Recommendation Report for Planning Permission

REF NO: BE/106/24/PL

LOCATION: Garage Compound at Westfield
Bersted
PO22 9HF

PROPOSAL: Erection of new residential garage unit. This application is in CIL zone 4 (zero rated).

Site location, block plan and site plan
Drawing GAR 001 rev A01
03.11.2024

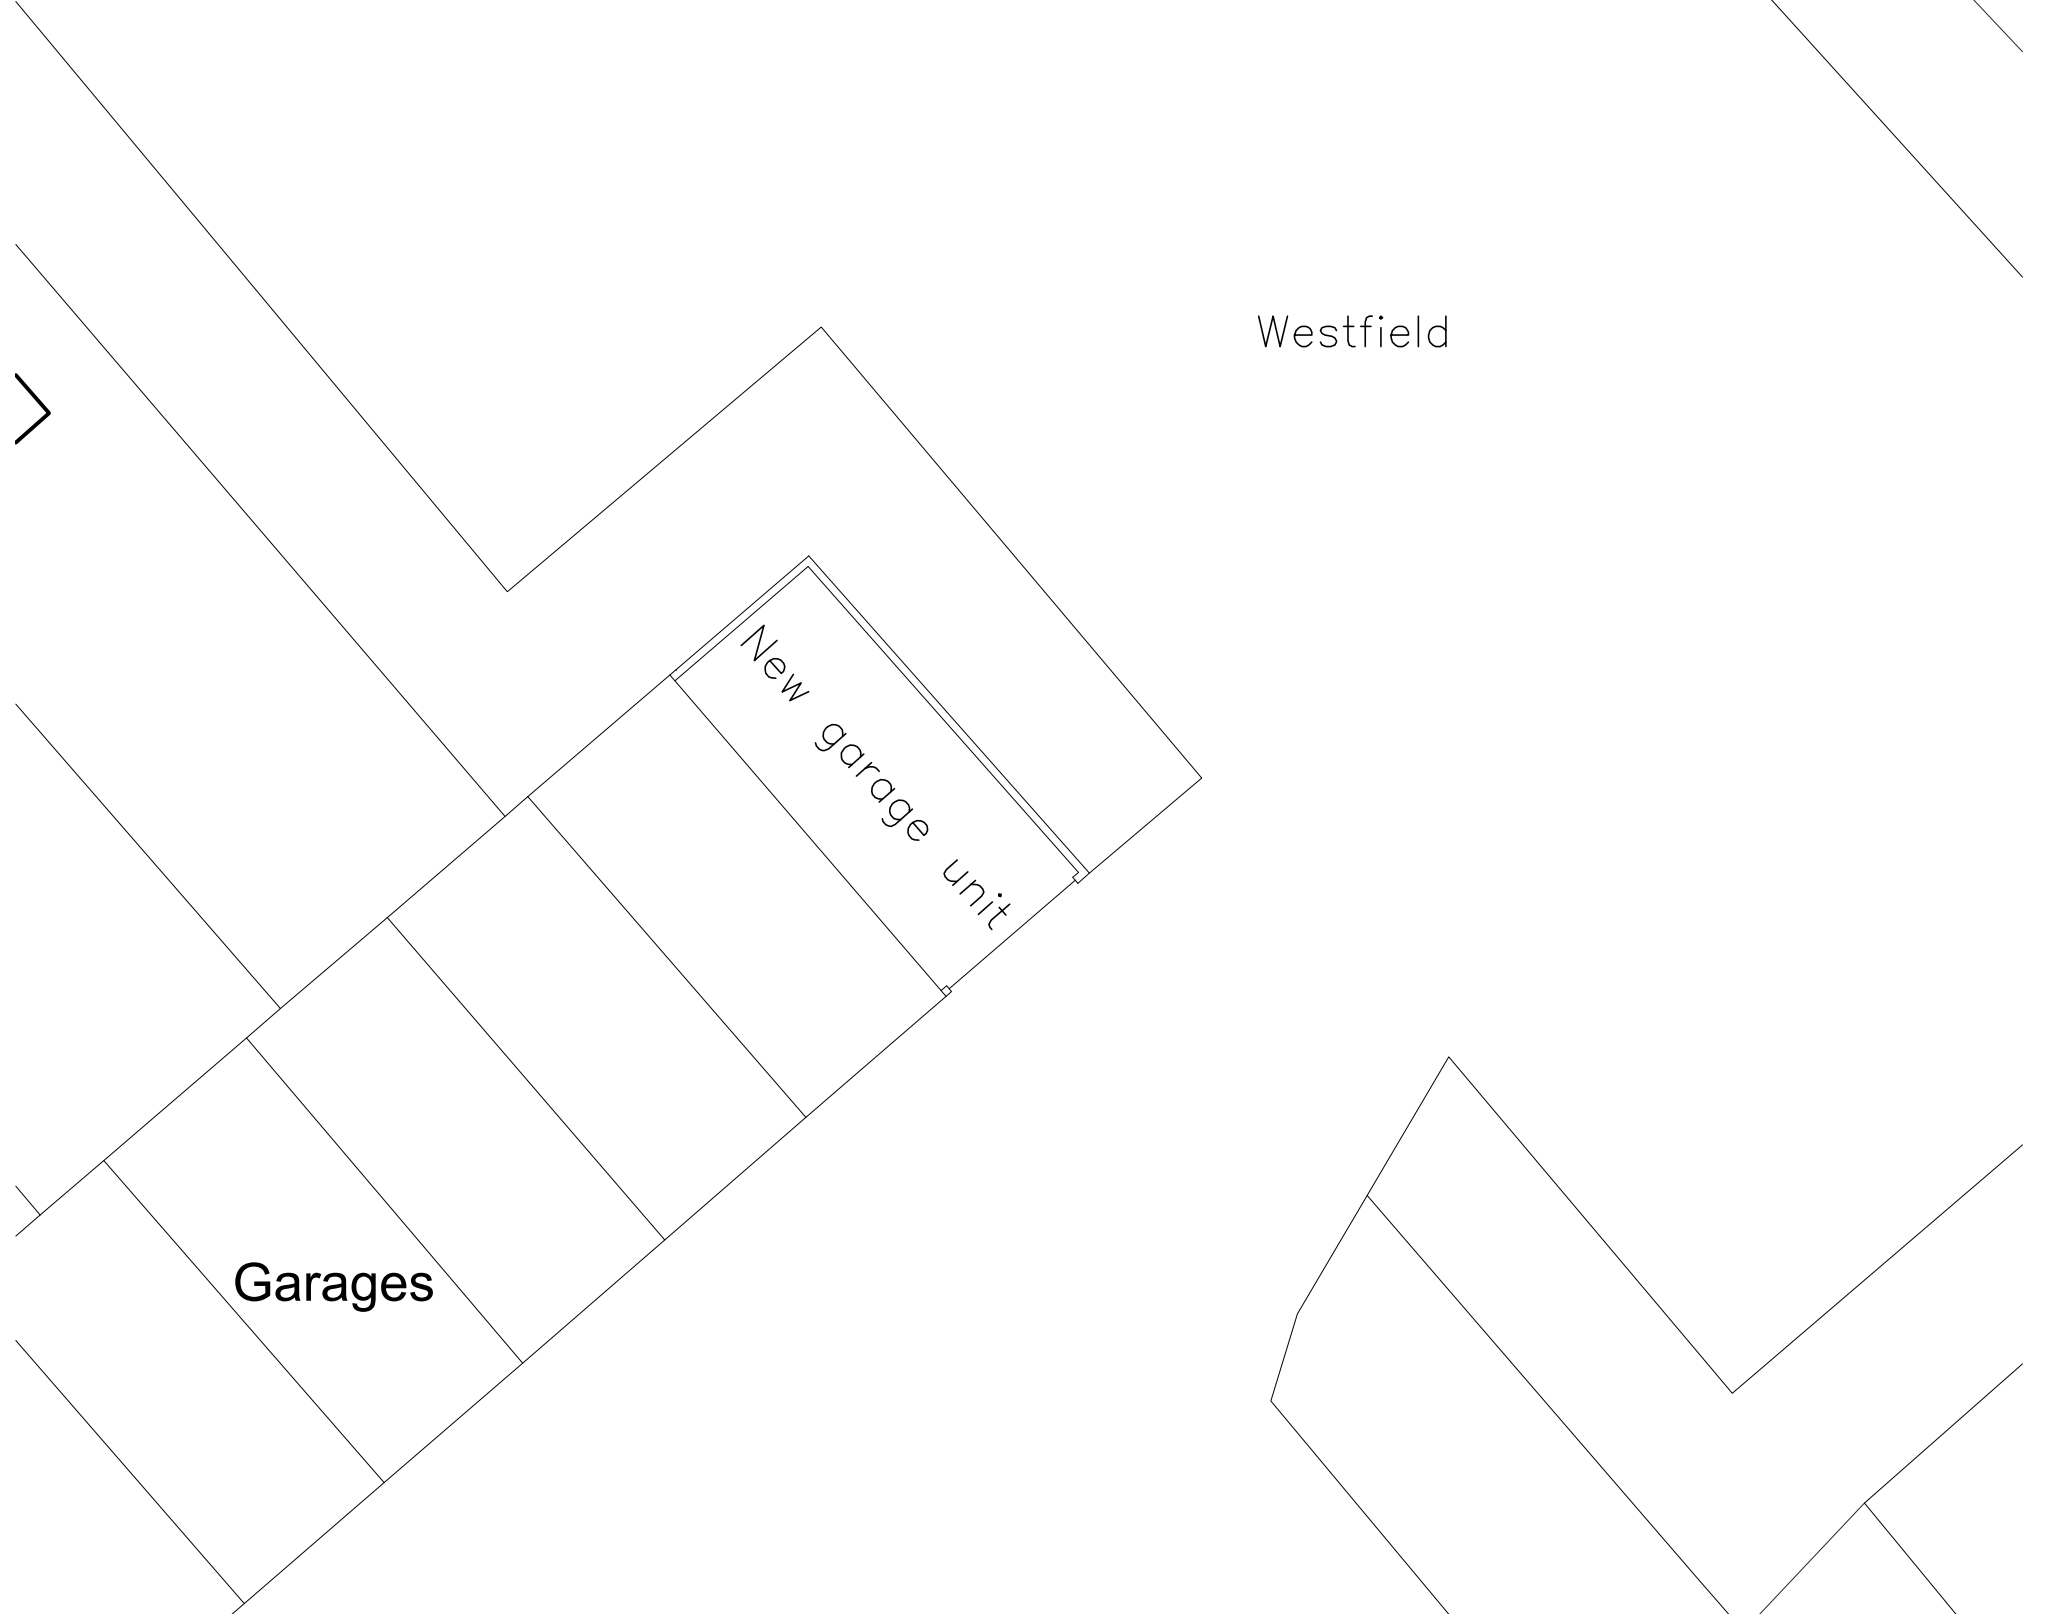
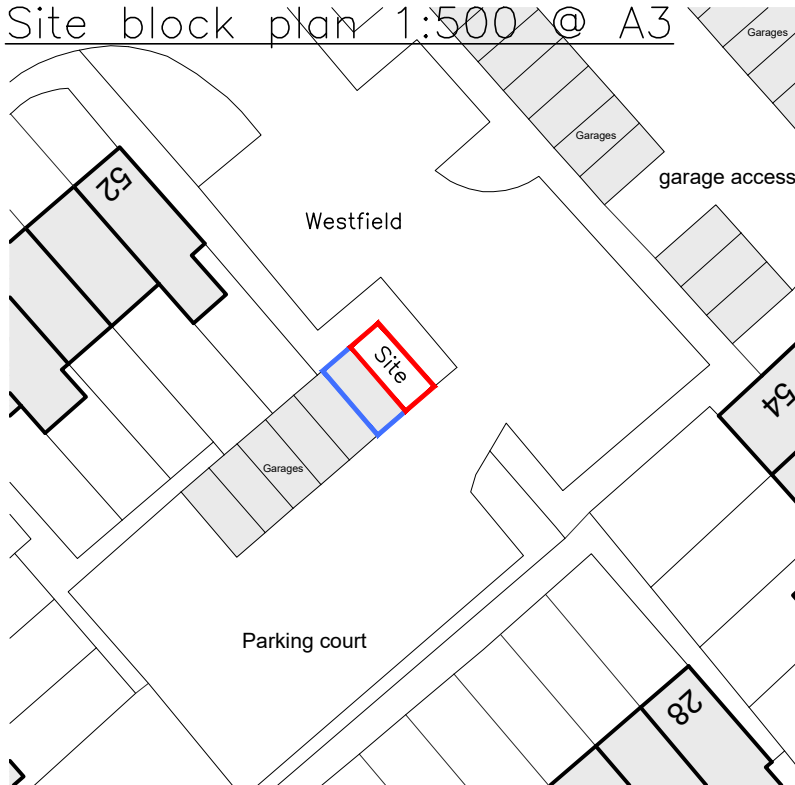
The proposed garage unit would adjoin the existing row of garages, with a width of 2.5m and a depth of 5.5m. The garage would have a flat roof with a height of 2.4m. A garage door is proposed to the front elevation of the garage.

Given the siting of the garage, at the end of a block of garages, and that the garage would be of the same scale and design as the existing garages, the garage would not appear unduly prominent within the street scene of Westfield, nor result in harm to the character of the street scene. The proposal therefore is in accordance with policy D DM1 of the Arun Local Plan.

The proposed garage would not be of a sufficient width or depth to accommodate a vehicle as per the Arun Parking Standards which outlines that garages should measure 3m by 6m. It is noted that concerns have been raised in relation to the loss of the existing parcel of land which is utilised informally for parking. The parcel of land is not an allocated parking space, and the existing arrangement is informal. Therefore, the proposal would not result in a loss of parking.
